From: Roy Gardner [REDACTED]
Sent: 16 March 2015 13:35
To: Planning; [REDACTED]
Subject: Message from Making Comments page

With ref. to planning application noAW/48/15/HH 16 Barrack Lane Mr and Mrs Keet

PROPOSED BOUNDARY WALL AT 16, BARRACK LANE, ALDWICK FOR MR. & MRS. T. KEET.

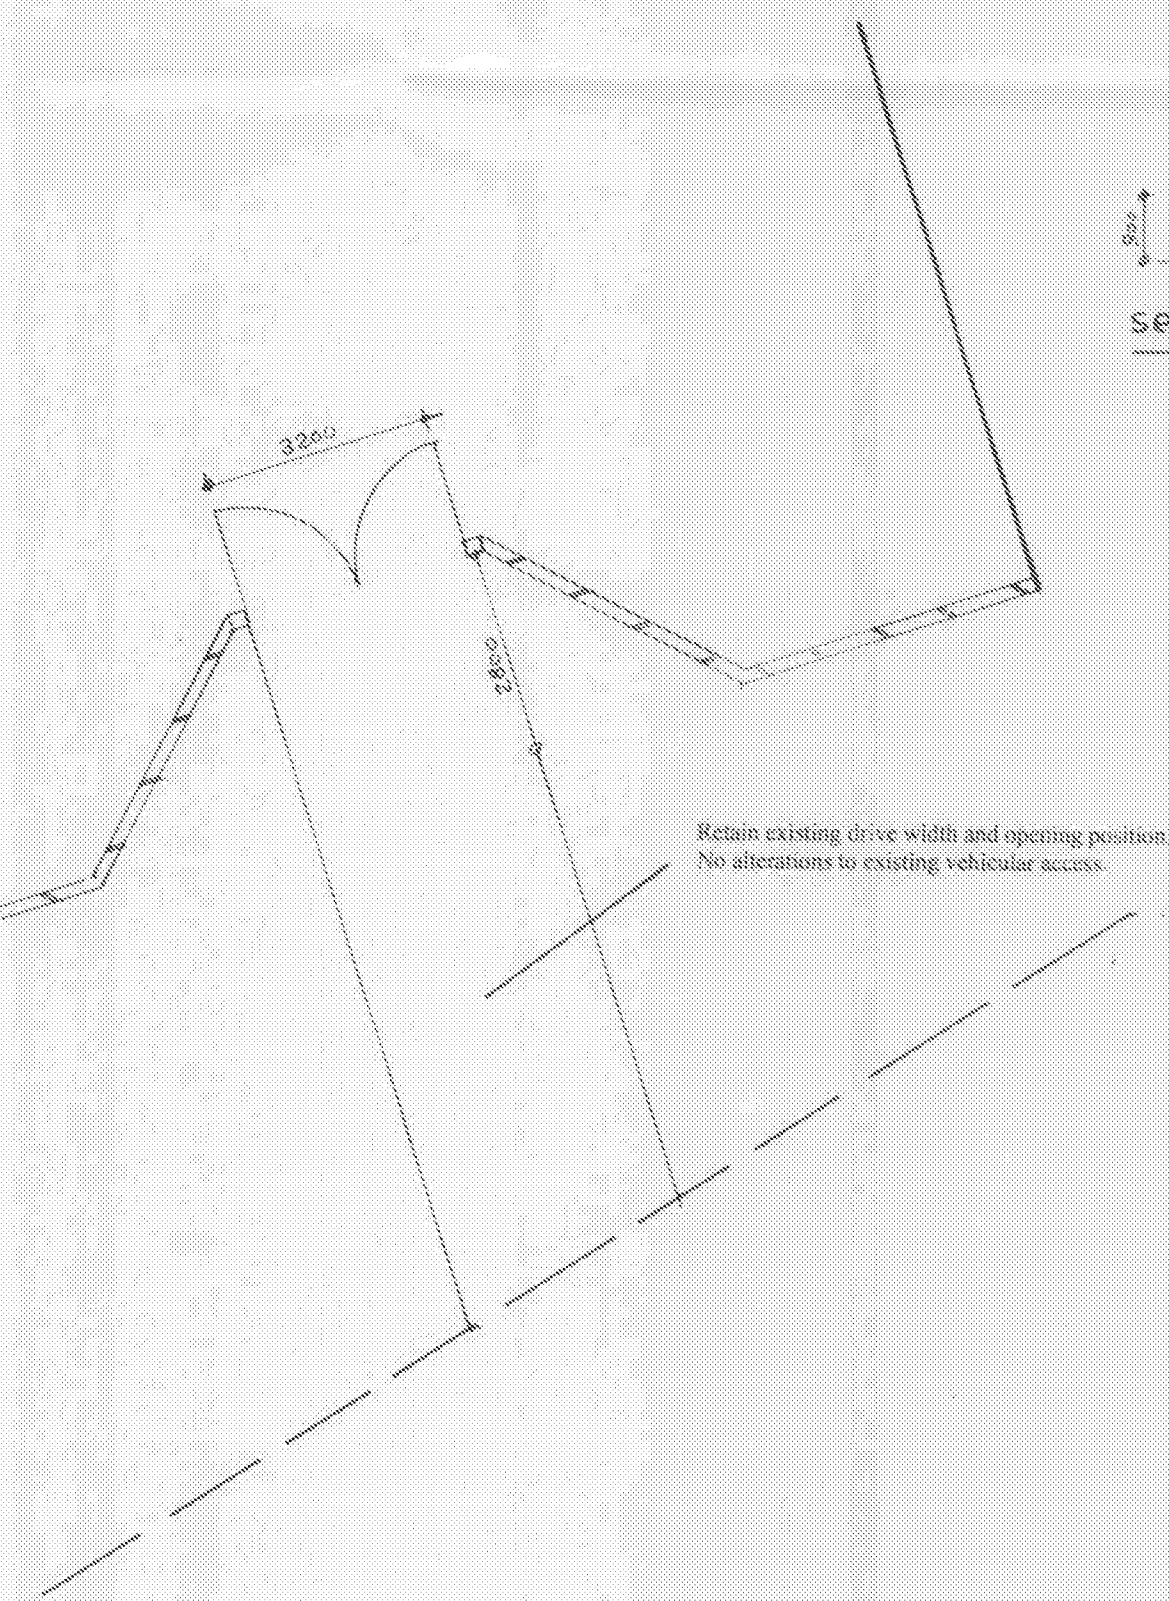
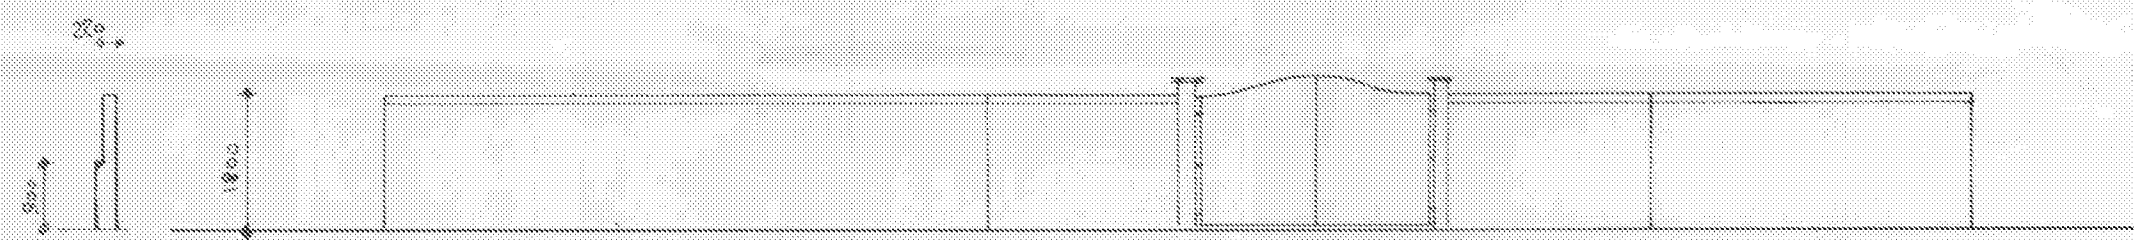
We note from the plans that a very high wall is intended along the frontage of number 16 and in answer to the question Will any trees or hedges need to be removed or pruned? the box has been ticked 'no'. We would query how this might be effected without removing existing hedges.

We would object to a wall of this height and the loss of natural habitat in a lane that traditionally been designated hedgerow along its entire length, thereby changing the character and ambience of the area. When the Gleesons site was established, hedgerows had to be planted as part of the planning application and there are no other walls of this height or solid gates along the length of the lane which would make this proposed construction totally out of keeping.

In answer to the question 16 : Can the site be seen from the public road and footpath, the box has again been ticked 'no'. yet the application includes the proposed front 1.8 metre high wall and solid gates which are actually ON the road.
